WEST SUSSEX COUNTY COUNCIL CONSULTATION

TO:	Arun District Council FAO:Mr S Davis
FROM:	WSCC - Highways Authority
DATE:	8 March 2019
LOCATION:	The Cottage Piggeries Church Lane Barnham PO22 0DB
SUBJECT:	BN/6/19/DOC Approval of details reserved by condition imposed under ref BN/19/18/PL relating to Condition Nos 4 materials & finishes, 5 new screen planting, 7 site set up during construction and 11 level survey.
DATE OF SITE VISIT:	n/a
RECOMMENDATION:	Advice
S106 CONTRIBUTION TOTAL:	n/a

The proposal seeks the approval of details reserved by condition imposed under ref BN/19/18/PL relating to Condition Nos 4 materials & finishes, 5 new screen planting, 7 site set up during construction and 11 level survey.

Site Layout Plan - Site set-up during construction

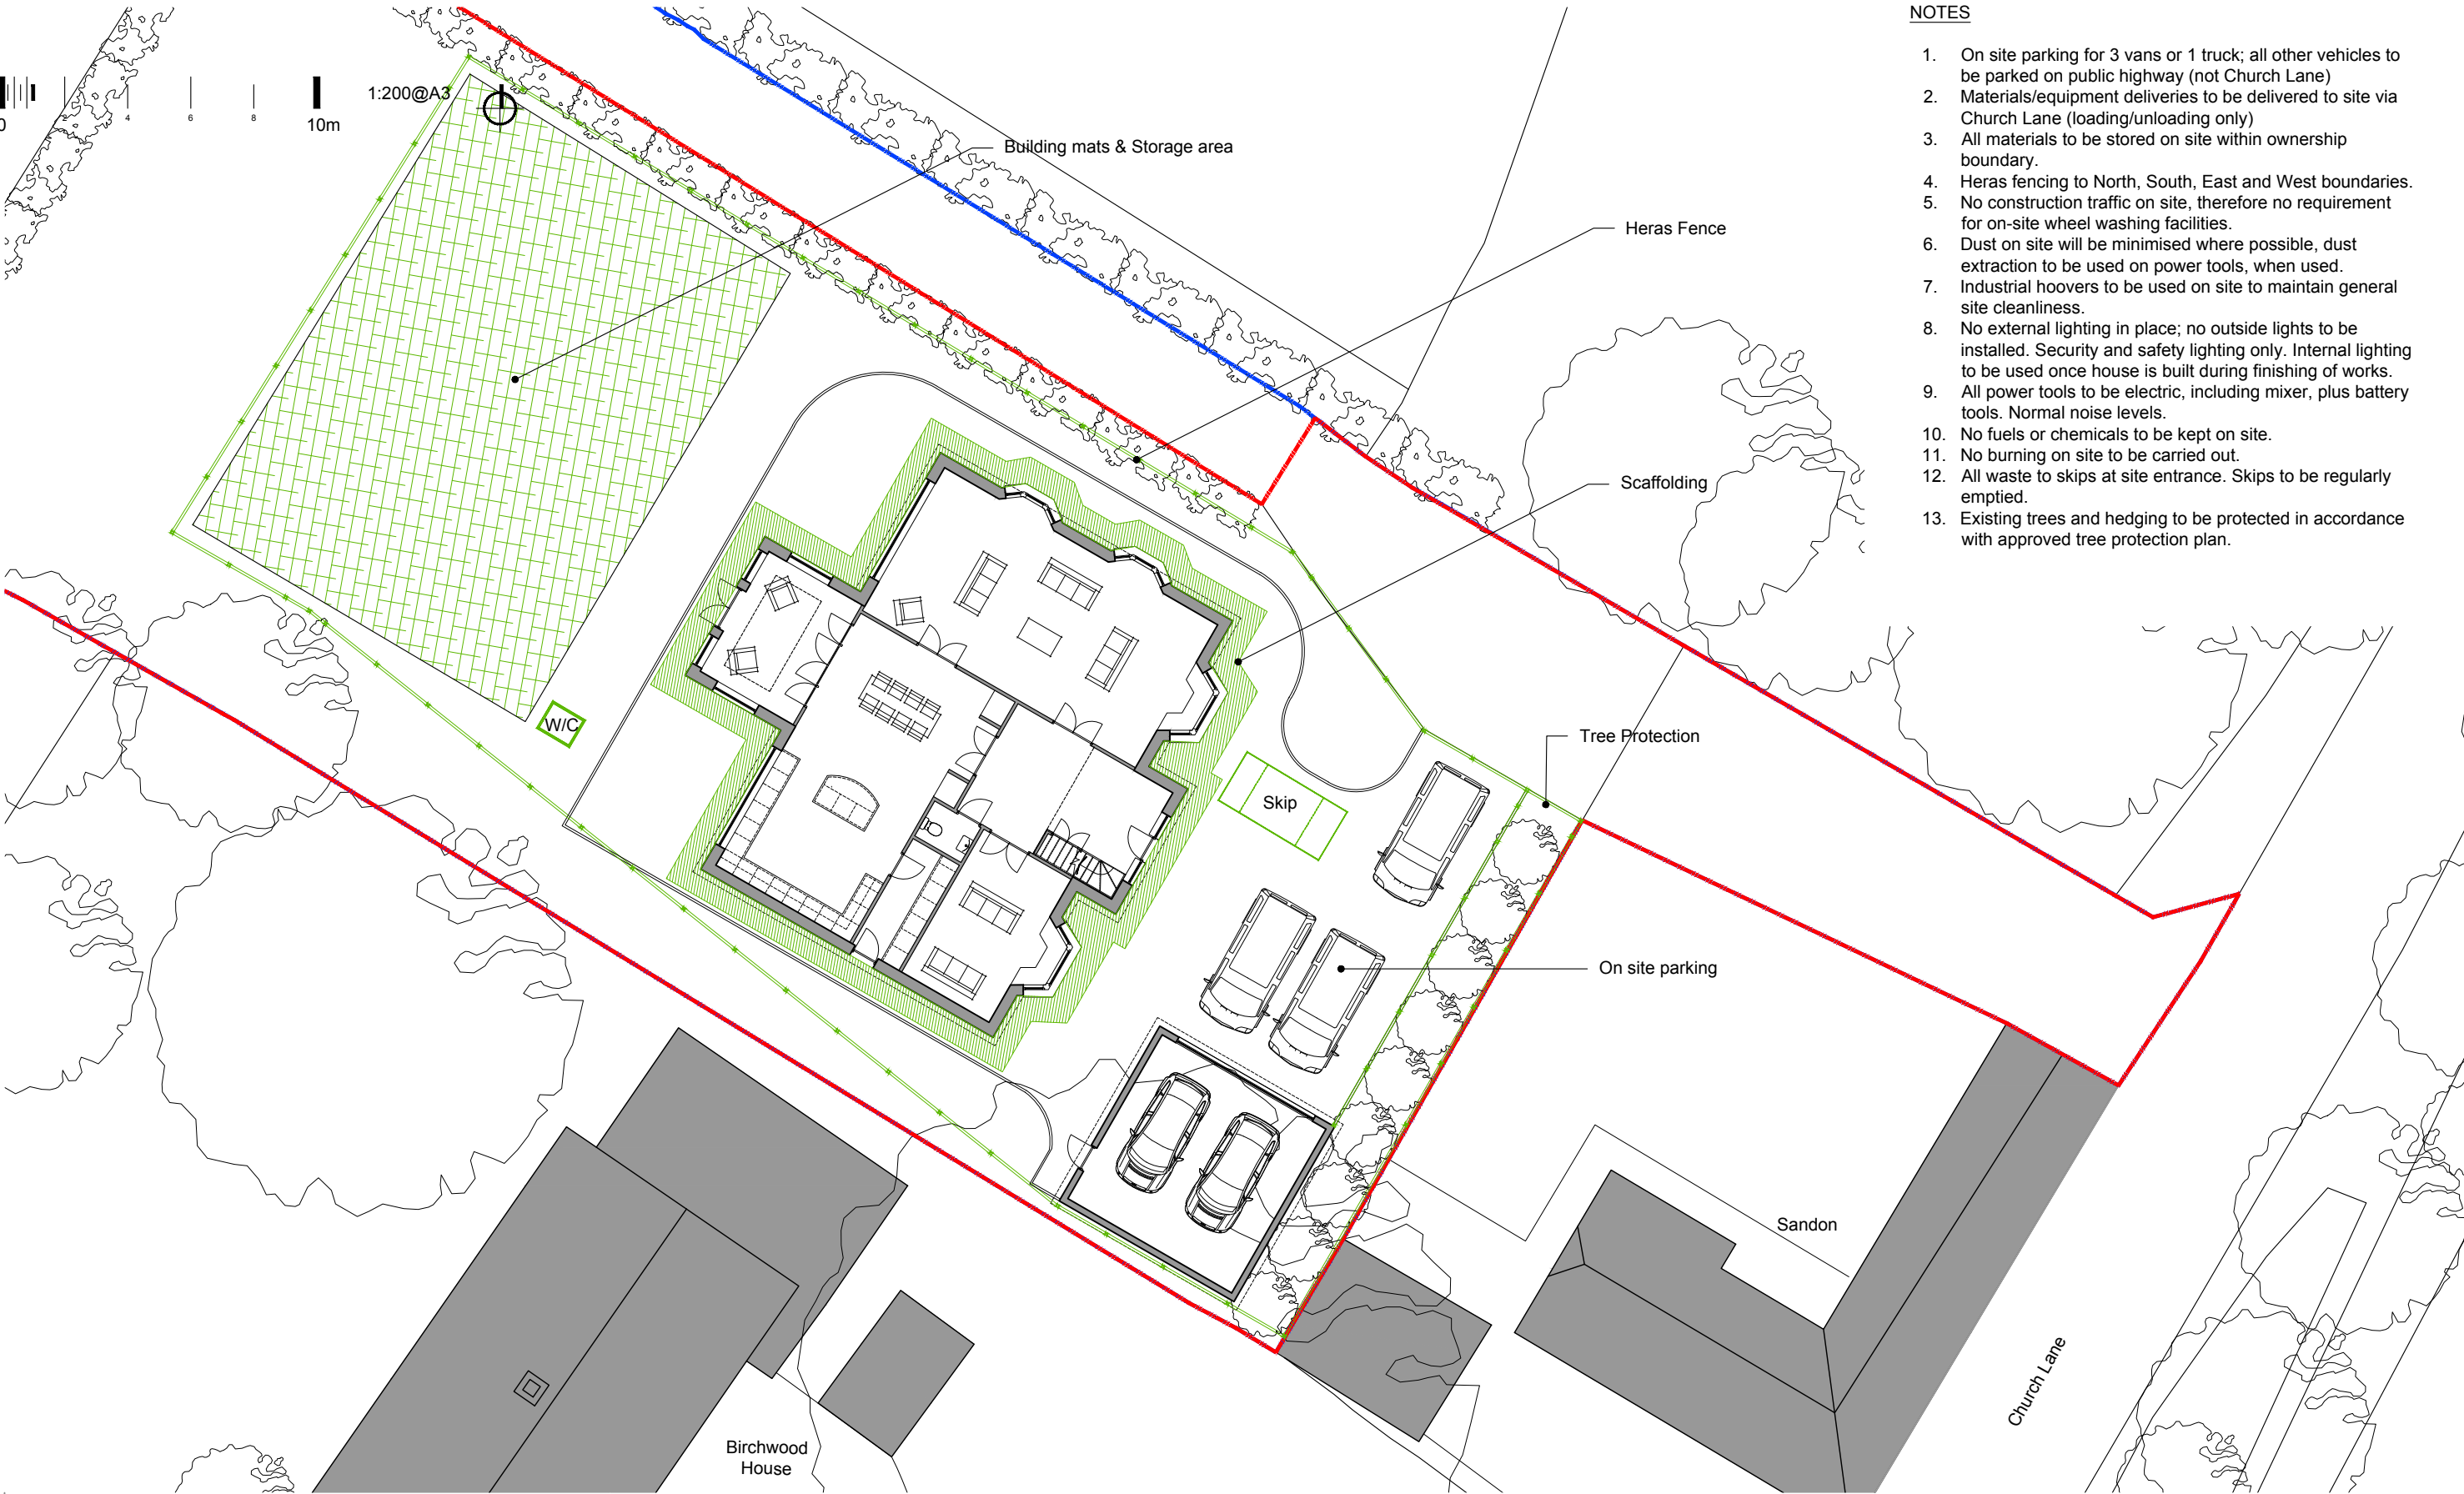
It would be requested an additional note is included to stipulate that any vehicles being required to reverse out of the site are assisted with the use of a competent banks person. Subject to this minor modification no highway concerns would be raised.
